Annex 1 – Oxfordshire County Council’s response to Cherwell District Council’s consultation on Phase One North West Bicester Eco-town (application: 10/01780/HYBRID): Detailed comments

Figure 5.3

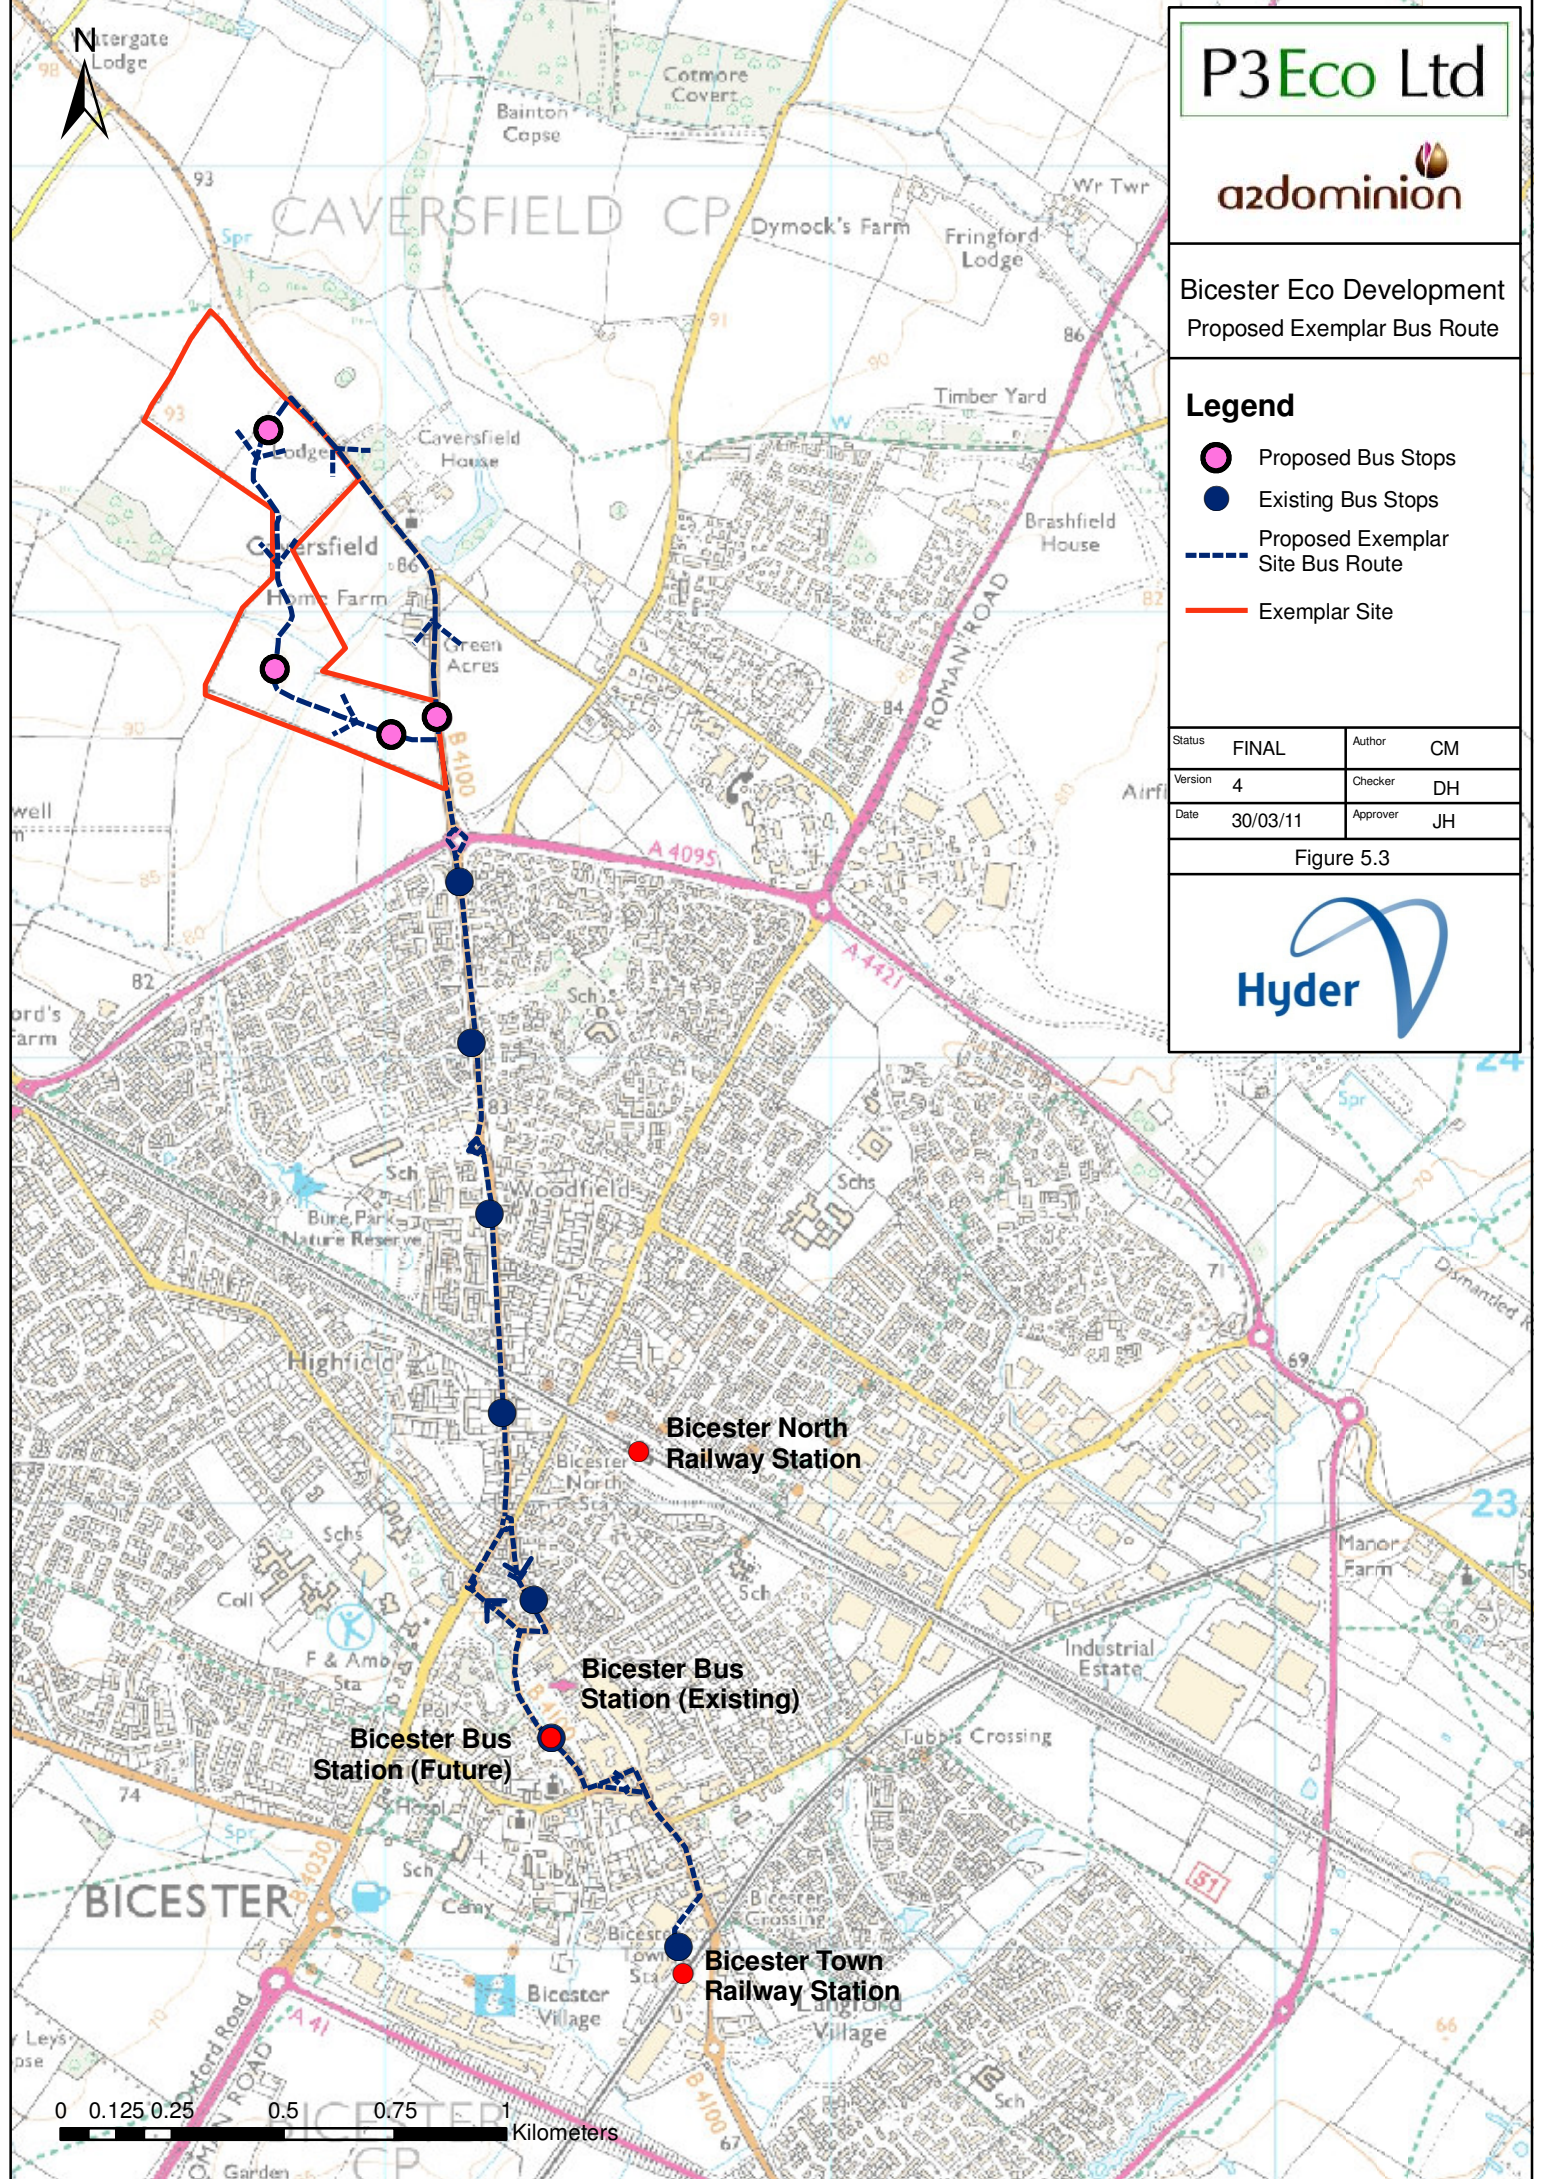
If the NW Bicester eco development is to be considered sustainable in terms of transport by promoting alternative travel modes for the development rather than that of the private car, it is deemed reasonable and essential that the proposed development provides a more frequent bus service than the 30-minute service currently proposed within the TA. The intention to seek ways to increase this is not enough. Innovative ways need to be explored to have a higher frequency from the start, such as community buses or peak time buses that meet the train times, etc. A 15 minute frequency is required.

Early weekday mornings will need to be achieved at the earliest opportunity to encourage commuters to London, and other external destinations to use the bus to travel to the train station. It is agreed that the route will be to from the site to the rail station(s) and the town centre.

Bus-only link – the link between the northern and southern parcels of the site must only be used by the bus services from the start so that this development meets the aspirations of PPS1 and the eco town status of Bicester. Emergency and refuse vehicles would have access too. Appropriate enforcement infrastructure would be required from the Developer such as camera enforcement, funding for a TRO, staff etc. This element of the residential development is seen as essential by the Local Highway Authority to promote sustainable travel. To give comfort to the Co-op there could be a clause to turn this into an all-vehicle link if the development does not expand as expected.

Public transport infrastructure i.e. bus stops/shelters are to be Real Time Information (RTI) and will be provided within 400m of all parts of the development. RTI in houses & other development uses within the site is to be provided – this piece of RTI equipment should cover rail timetables as well as buses for Bicester.

No cycle parking is mentioned at these locations – which is required.
